**REQUEST**

Current Zoning: R-3 AIR LLWPA (single family residential, airport noise overlay, Lower Lake Wylie Protected Area) and B-2 AIR LLWPA (general business, airport noise overlay, Lower Lake Wylie Protected Area)  
Proposed Zoning: I-1(CD) AIR LLWPA (light industrial, airport overlay, Lower Lake Wylie Protected Area)

Approximately 13.22 acres located on the north side of Business Center Drive and Interstate 85 and west of Little Rock Road.

**SUMMARY OF PETITION**

October 12, 2020

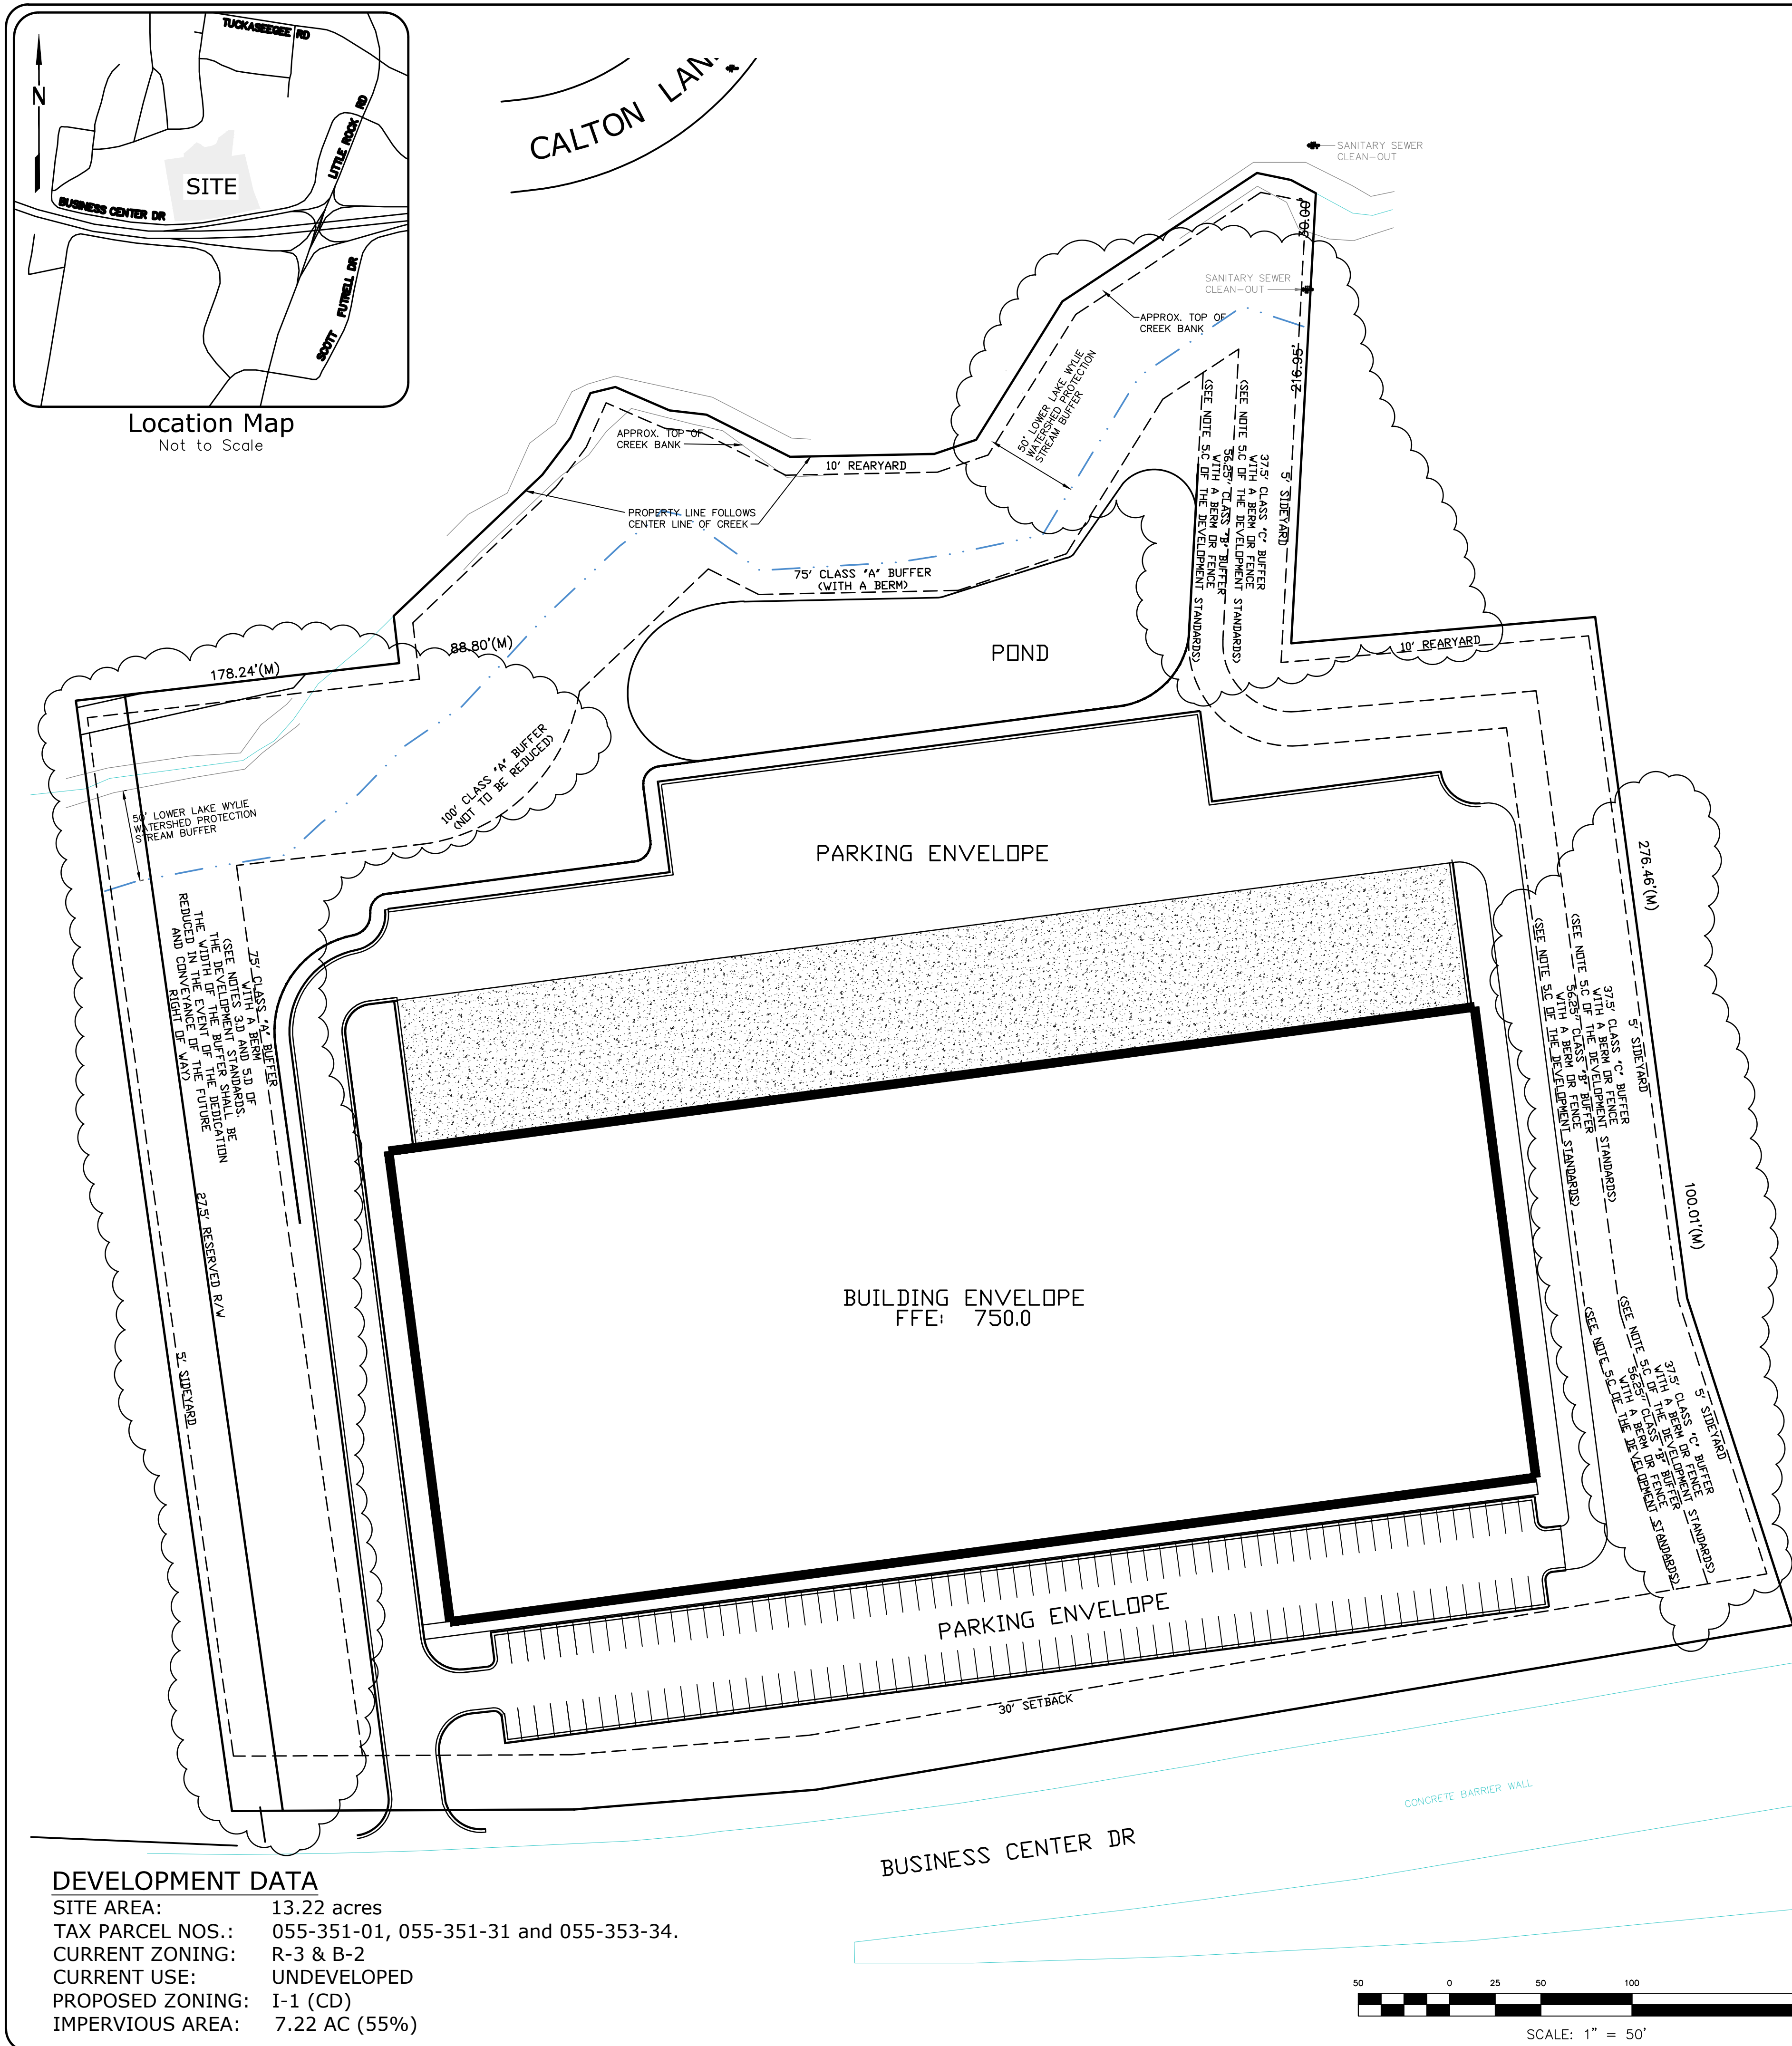
1. Revise the site plan and conditional note(s) to commit to dedicate right-of-way 2-ft back-of-sidewalk on Business Center Drive, labeled and dimensioned from the road centerline.
2. Revise the site plan and conditional note(s) to commit to construct an 8-foot planting strip and a 6-foot sidewalk along the site's Business Center Drive frontage, per Charlotte WALKS, labeled and dimensioned from the road centerline.

3. Stream buffers are incorrectly labeled. Applicability of stream buffer requirements will depend upon stream classification ("intermittent" stream will require 35' PCSO Buffer; "perennial" stream will require 100' watershed buffer). For purposes of advancing the rezoning process, show and label "Potential 35' PCSO Stream Buffer" and "Potential 100' Undisturbed Lower Lake Wylie Watershed Protection Stream Buffer" on the rezoning plan OR provide stream delineation report confirming no intermittent or perennial stream exists (report subject to review and approval by City).

4. Add the following note under the ENVIRONMENTAL FEATURES heading:  
"Development within any PCSO/Watershed Protection Stream Buffer shall be coordinated with and subject to approval by Charlotte-Mecklenburg Storm Water Services and mitigated if required by City ordinance. Petitioner acknowledges intermittent/perennial stream delineation reports are subject to review and approval upon submission of development plans for permitting and are not approved with rezoning decisions."

5. Label zoning of all adjacent parcels.
6. Relocate the berm on the western property line to be outside of the reserved right-of-way. If future right-of-way is dedicated, a half buffer (50') is required and can be reduced 25% per ordinance with a berm.
